Rezoning Transportation Analysis

Petition Number: #2022-048

From: Jake Carpenter, PE
Jacob.Carpenter@charlottenc.gov
980-221-5675

Date	Description
08-25-22	First Review (PDM)
09-22-22	Second Review (PDM)
10-27-22	Third Review (TM)
11-28-22	Fourth Review (TM)
01-25-23	Fifth Review (DR)
04-06-23	Sixth Review (TM)
04-25-23	Seventh Review (TM)

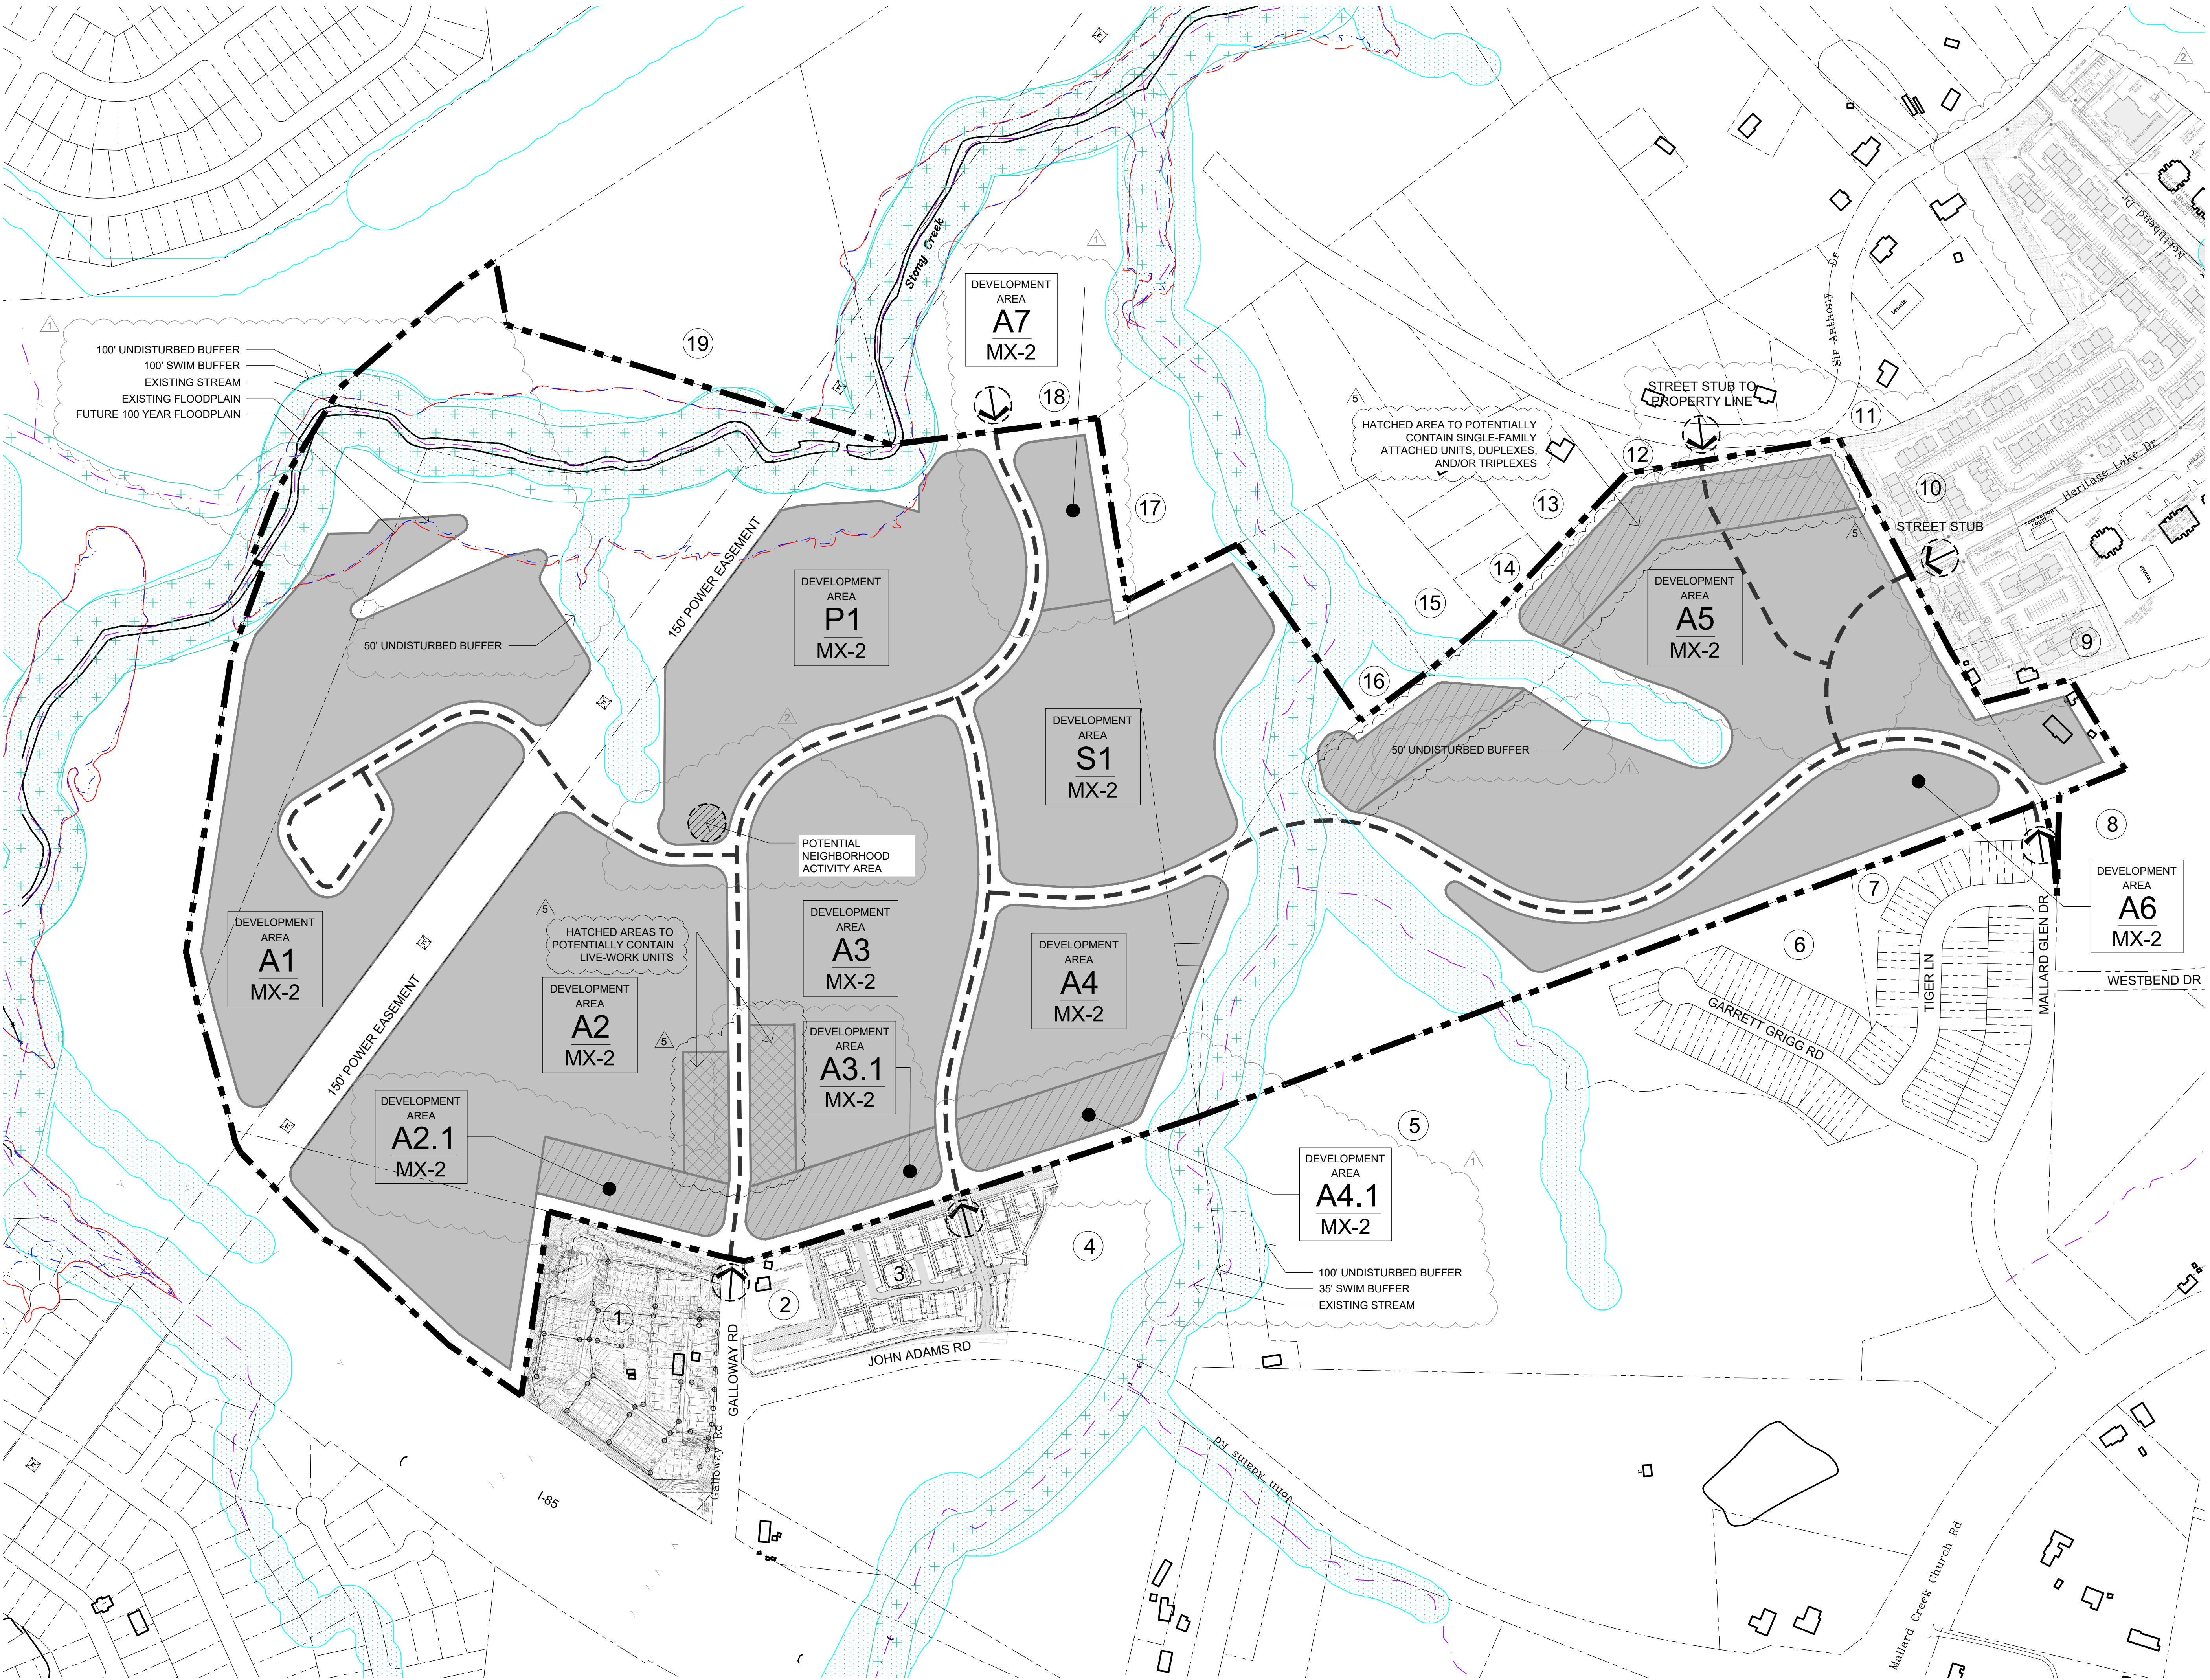
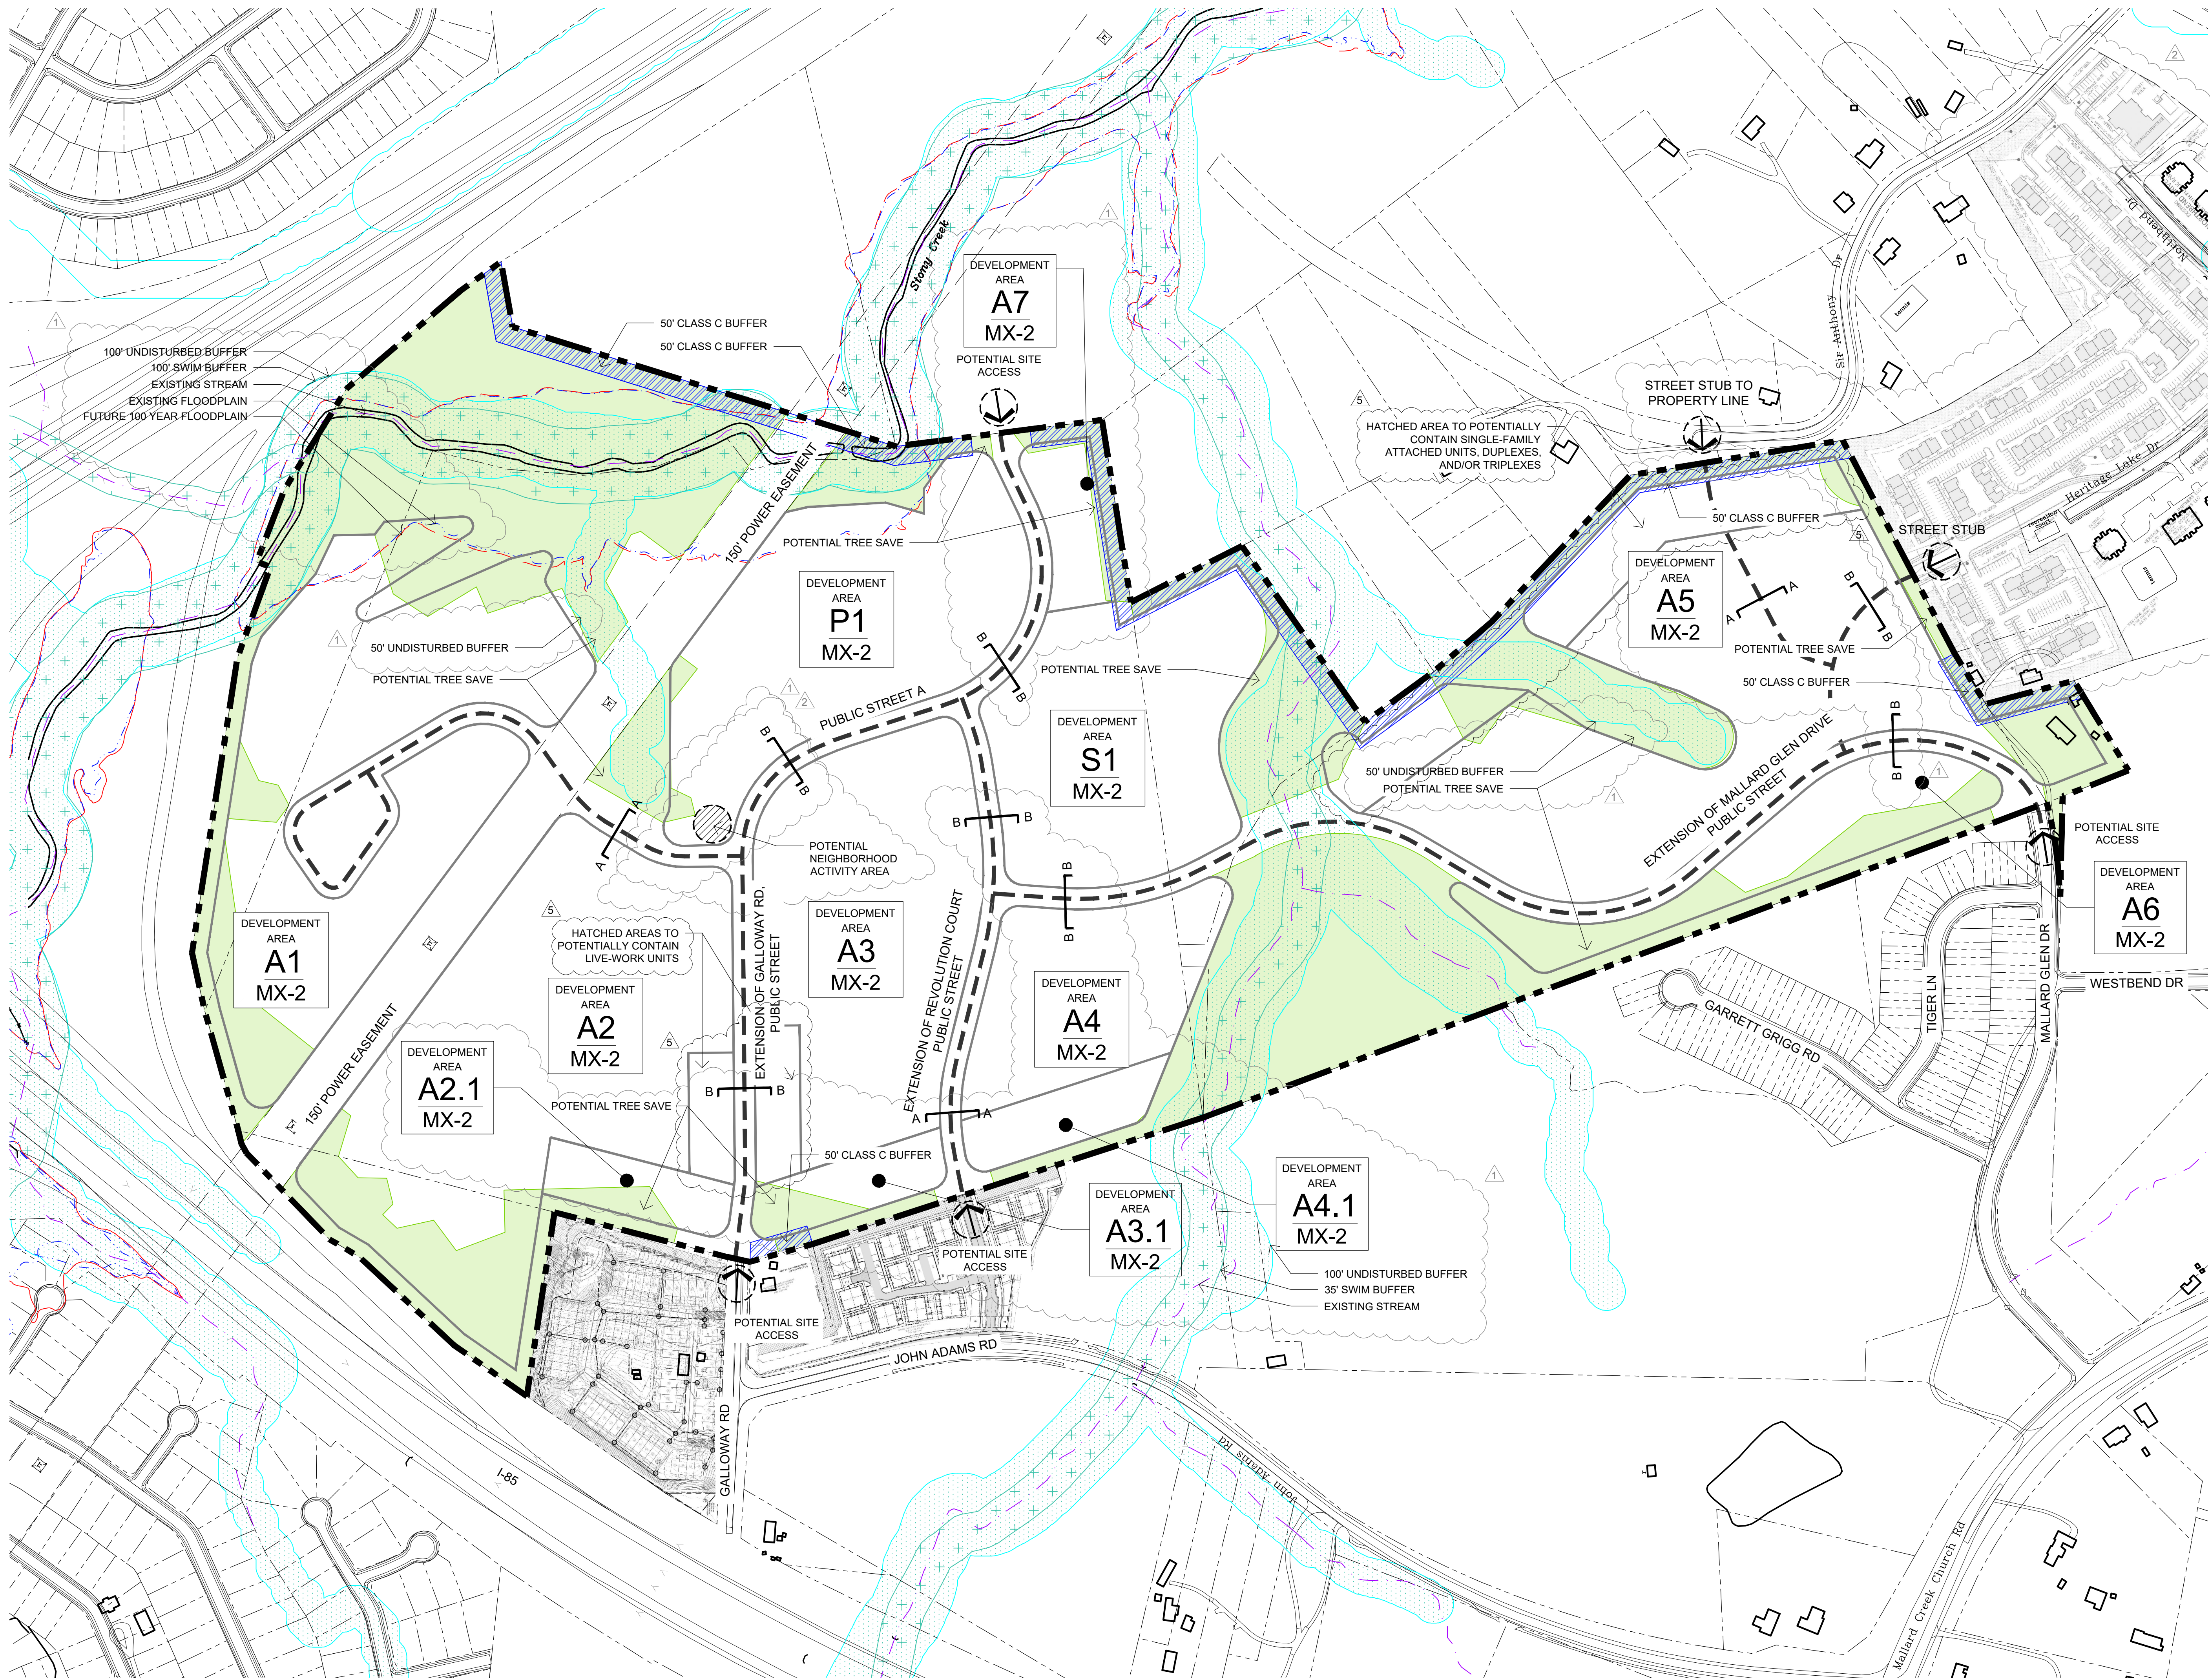
Updated Comment 04-25-23: Revise site plan conditional notes to include the following improvements from the approved TIS:

- The Mallard Creek Church Road and Mallard Glen Drive intersection improvements need to have two separate improvements with regards to the southbound left turn lane as shown below:

- “Provide a southbound left turn lane on Mallard Glen Drive with 150 feet of storage and appropriate deceleration/taper before the first CO.” This improvement would be tied prior to the first CO.

- “Provide a second southbound left turn lane on Mallard Glen Drive with 150 feet of storage and appropriate deceleration/taper prior to 401st residential CO.” The improvement would be tied prior to the 401st CO.

- The Mallard Glen Drive and Mallard Highlands Drive intersection improvement needs to be updated to being tied prior to 401st CO. Second receiving lane on Mallard Glen Drive is not needed initially.

2. **New CDOT COMMENT 04-06-23:** Revise site plan and conditional notes by committing to upgrading Northbend Drive and Heritage Lake Drive to public street standards.

Clarifying Comment 04-25-23: Revise conditional note to say “Petitioner shall coordinate with CDOT to upgrade pavement and stormwater infrastructure along Northbend Drive and Heritage Lake Drive to public street standards in coordination with CDOT street acceptance team during permitting, as improvements are reasonably able to be completed within the existing right-of-way and no additional right-of-way acquisition would be required to perform the improvements”
